April 22, 2026

ATTN: Inspections Staff
RE: Forest Lakes Filing 7 - Pond A

Project: **FOREST LAKES FILING 7**

Basin ID: **POND A - ASBUILT**

**8'X4' OUTLET BOX ORIFICE PLATE**  
SCALE 1" = 2'

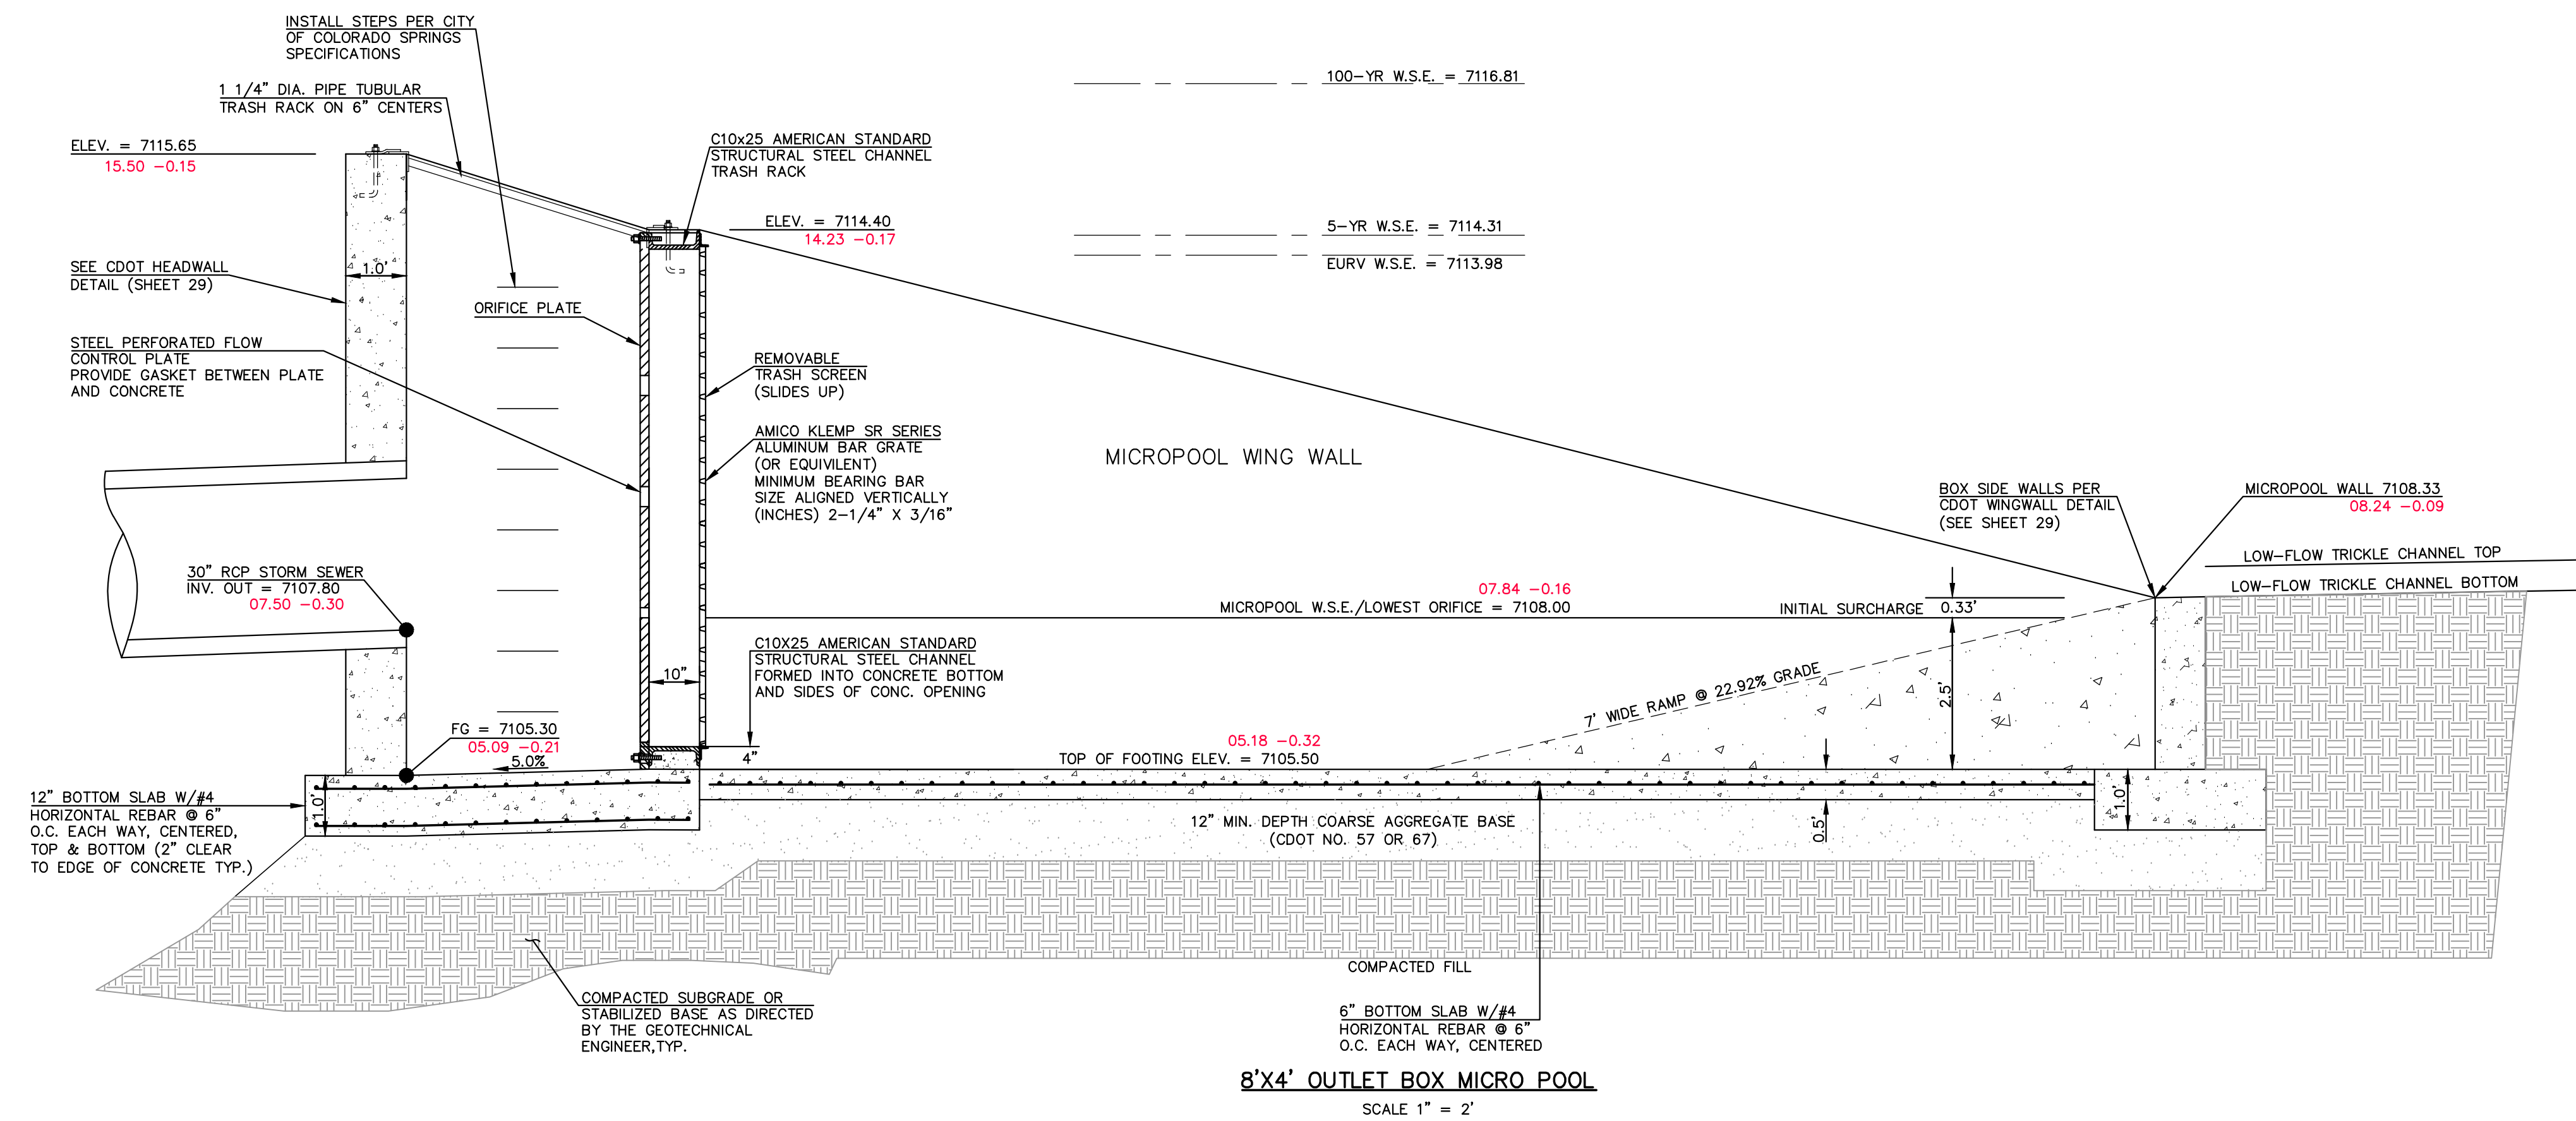
still doesnt match as-built CDs. See my comment on Sht 25 of CDs.
